RE: Huntlee Mod9 Response to Submissions

I write to you on behalf of Huntlee Pty Ltd in regard to the S4.55 2 Modification Application (MOD 9) to Project Approval MP10_0137.

Table 1 Supplementary Response to submissions

DRAWING TITLE: 20406-1 TO 3000 (MOD9) AS CHANGED FROM MOD 10 REV. 8

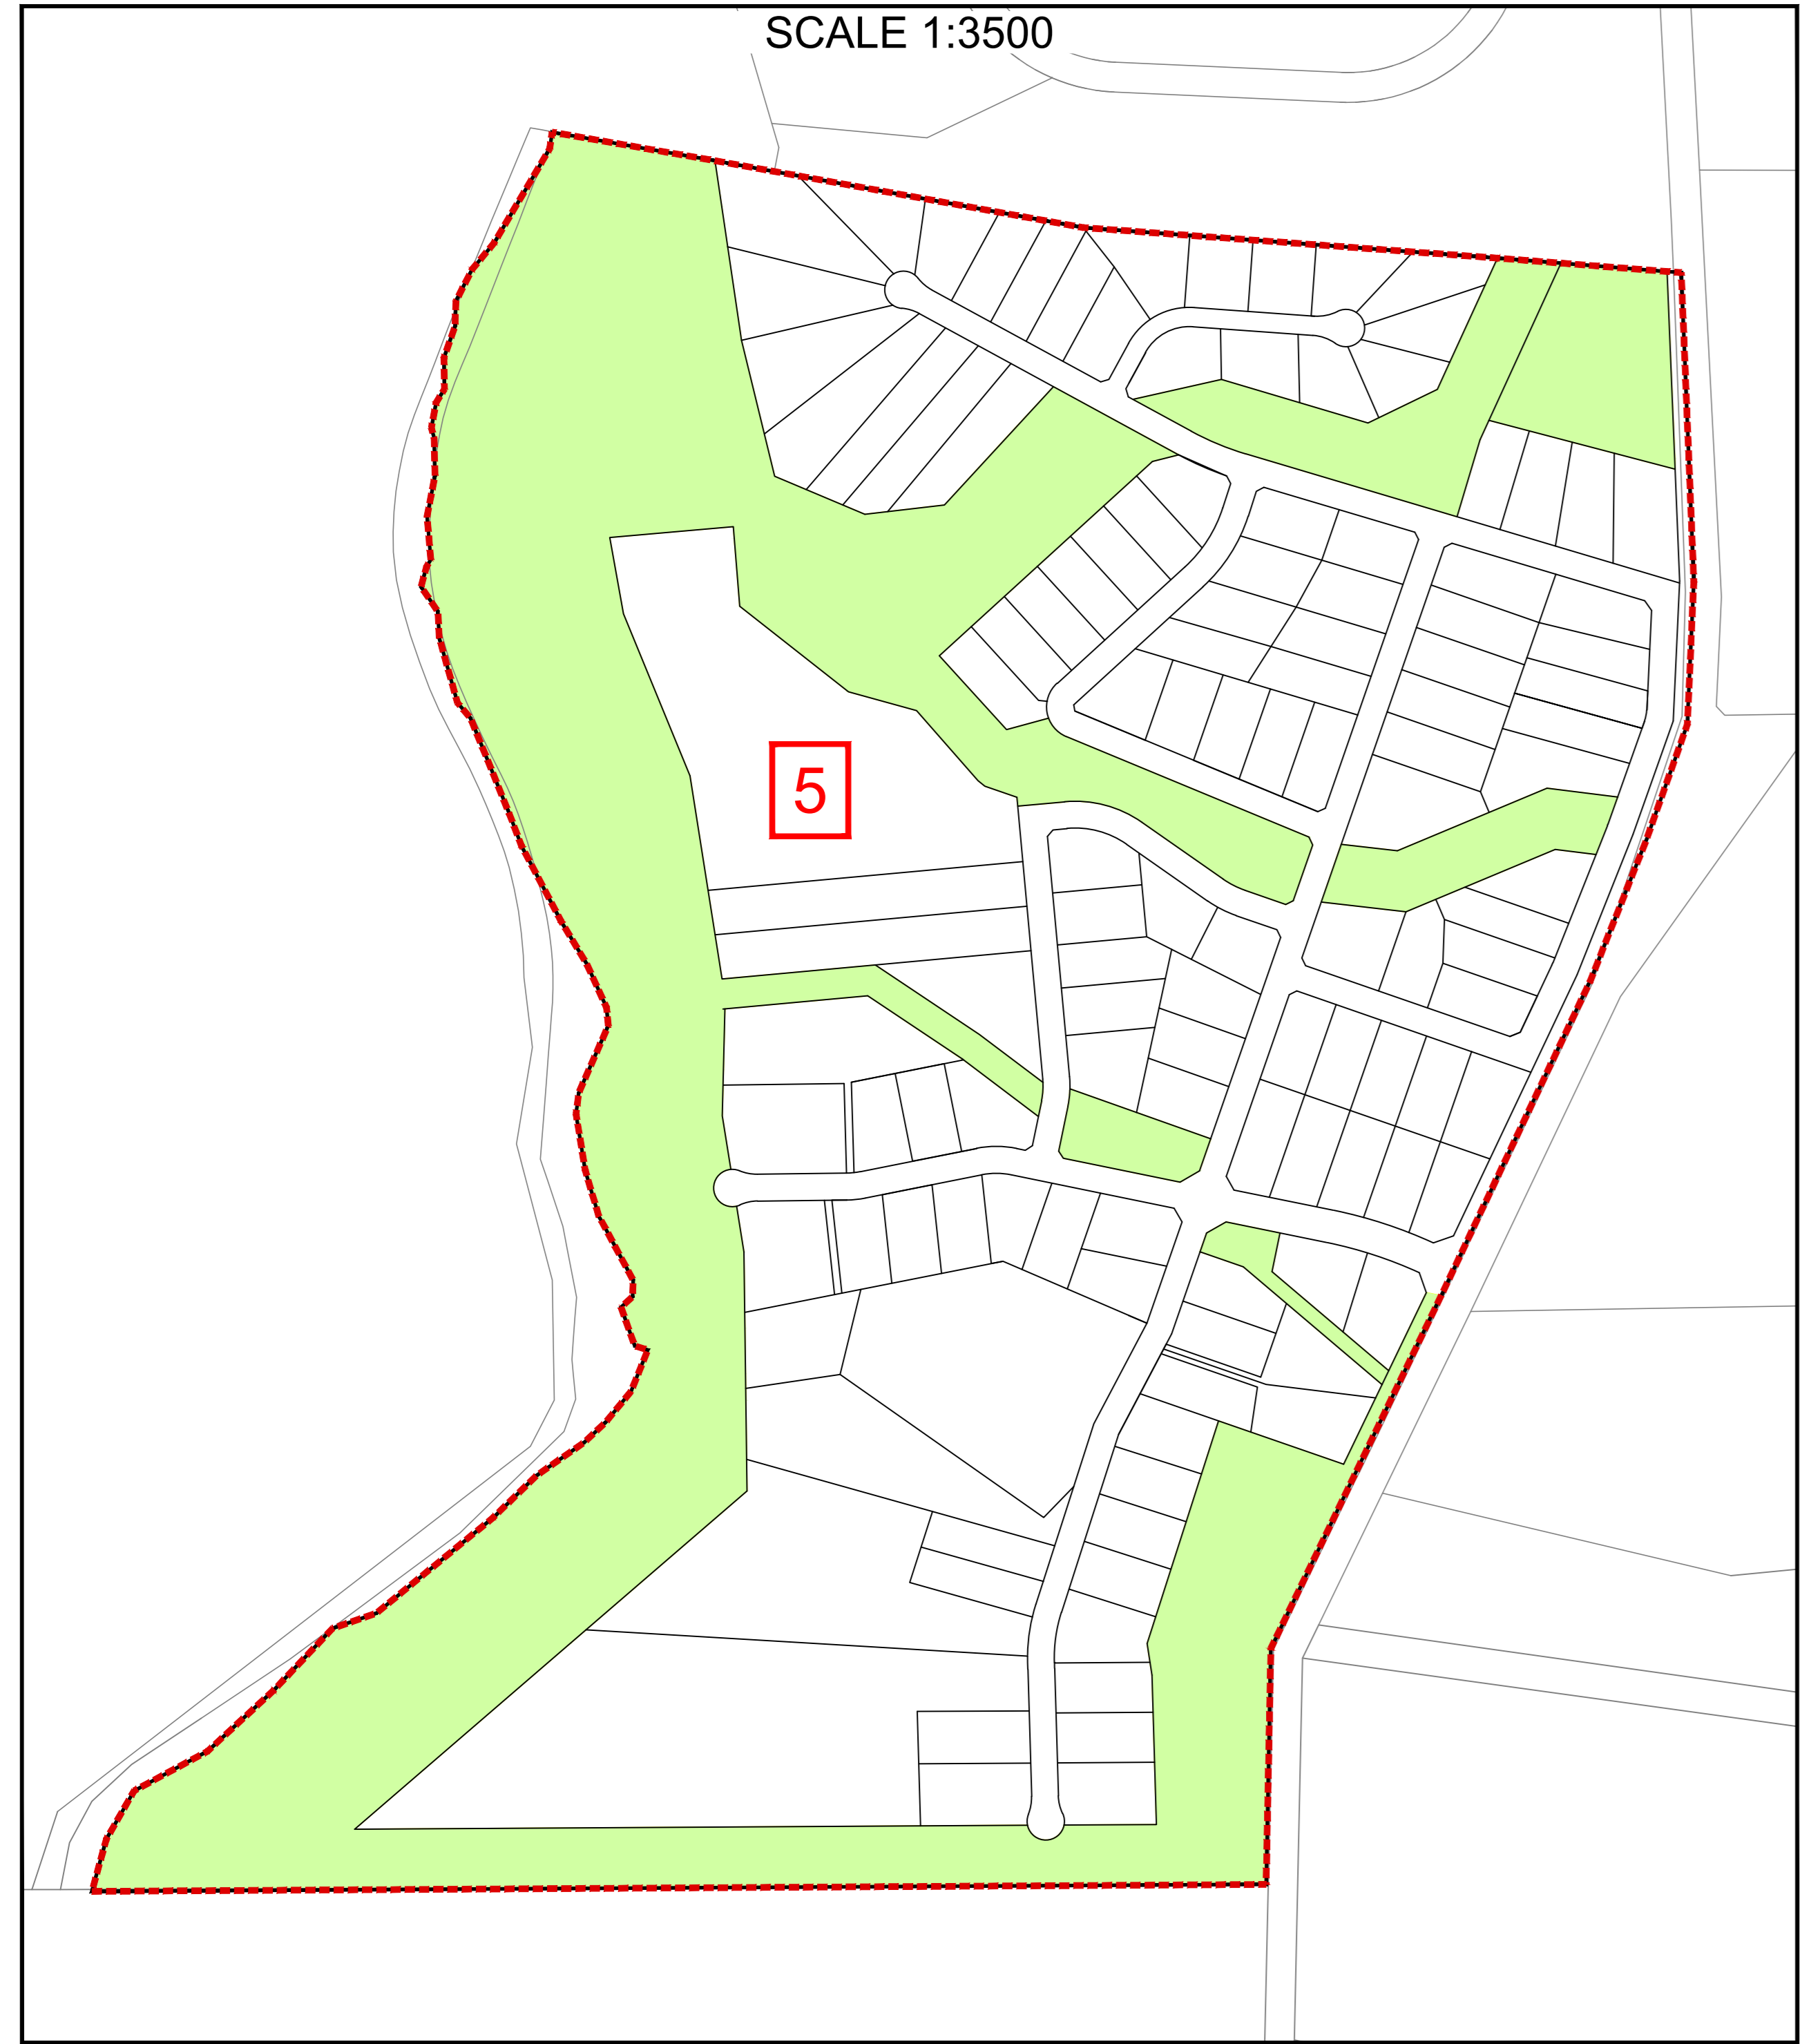
Submissions	Response
Department of Planning and Environment (DoPE)	
1. Plan information and proposed changes • Clarify changes • Overlay all environmental constraints • Indicate riparian corridor width on the stormwater concept and open space plans. • Indicate the required APZs are outside the core vegetated riparian corridors and are located within the development boundaries.	• Updated masterplan and overlay plans highlighting all changes following Mod 10 with environmental constraints including APZ and riparian corridors are provided in Attachment A. • Riparian corridor width is indicated on the open space plan (Attachment B) and stormwater strategy. • The updated flooding extents for both tributaries are provided within the Northrop response in Attachment C. Riparian corridor width has been reflected in the stormwater strategy.
